CITY OF ALBUQUERQUE

June 7, 2019

Re: Warm Shell Renovation
807 4th st SW, Albuquerque NM 87106
Traffic Circulation Layout
Engineer's/Architect's Stamp **06-03-2019** (K14D116)

A1 SITE PLAN
1" = 10'-0"

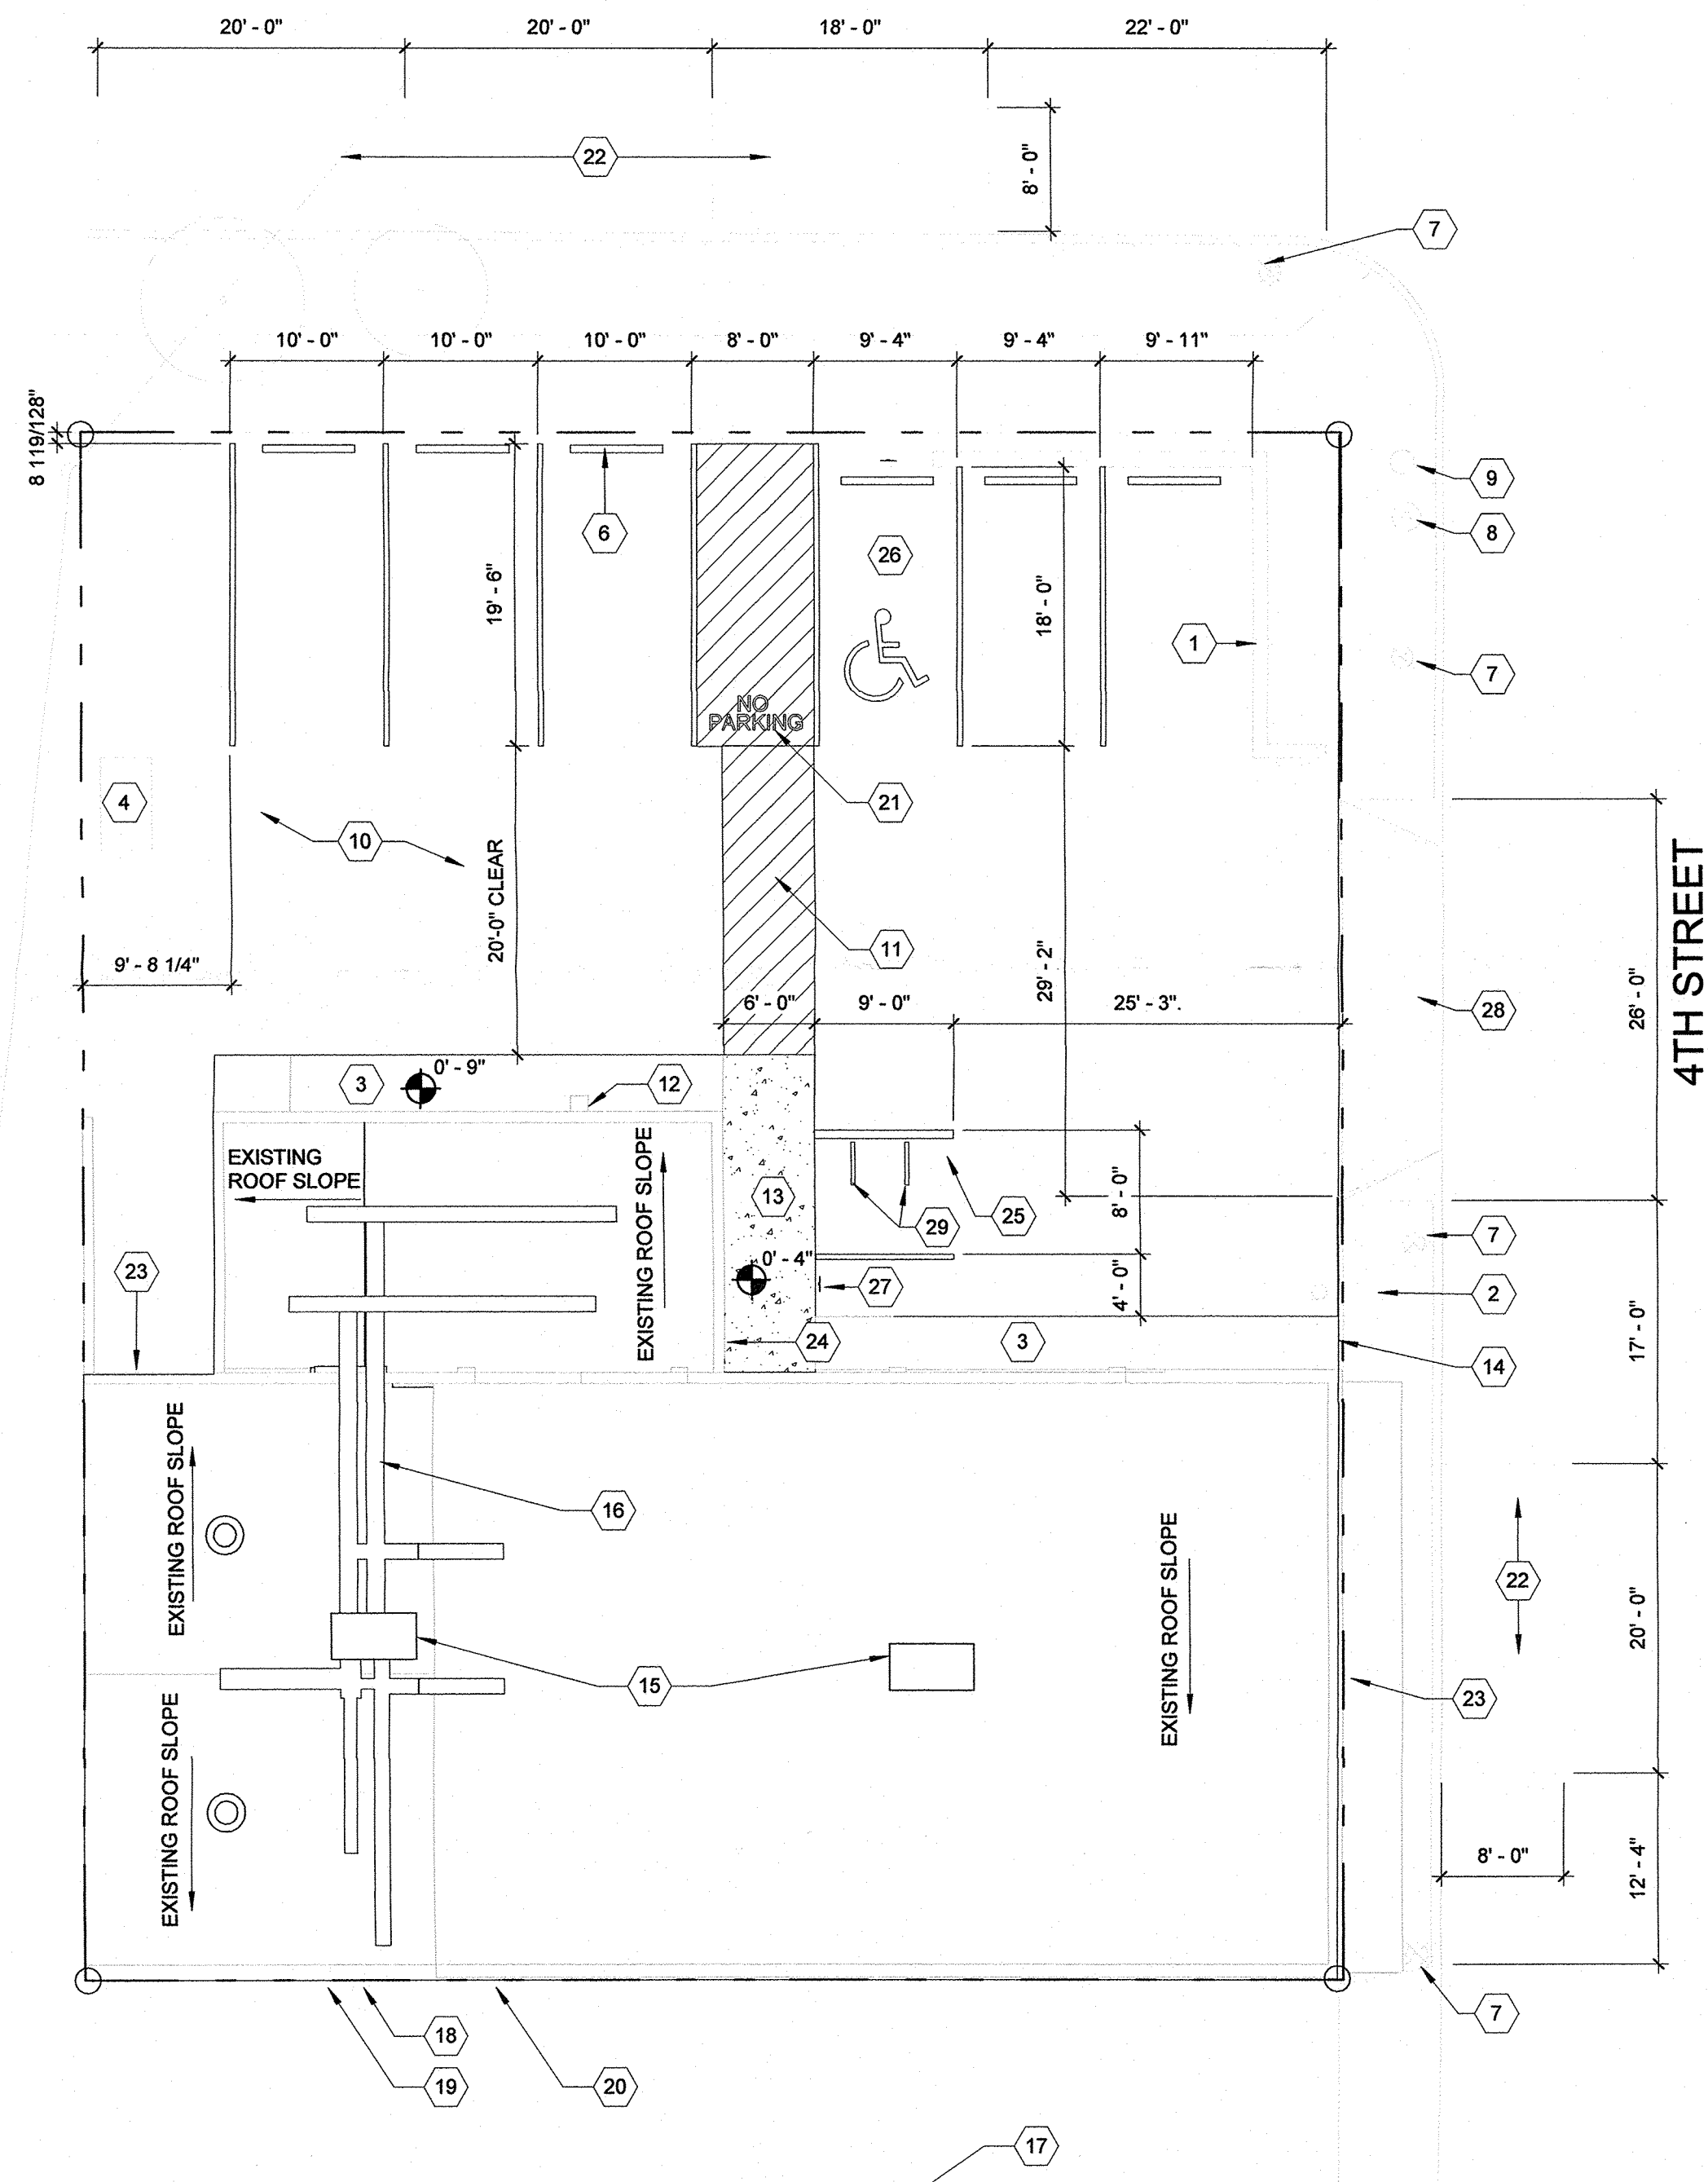
1. The handicap accessible spaces must include an access aisle. Van accessible aisles should be 8ft wide.
2. The ADA access aisles shall have the words **"NO PARKING"** in capital letters, each of which shall be at least one foot high and at least two inches wide, placed at the rear of the parking space so as to be close to where an adjacent vehicle's rear tire would be placed. (66-1-4.1.B NMSA 1978)

3. Motorcycle parking spaces shall be designated by its own conspicuously posted upright sign, either free-standing or wall mounted per the zoning code.

4. Show all drive aisle widths and radii. Some dimensions are not shown.
5. In the existing design the parking space is in front of the drive way. Change the configuration of the parking in a way that parking space is not located in front of the access. Or close the existing curb-cut in 4th street and open a new curb cut in Hazeldine.

6. Show the location of the on-street spaces.
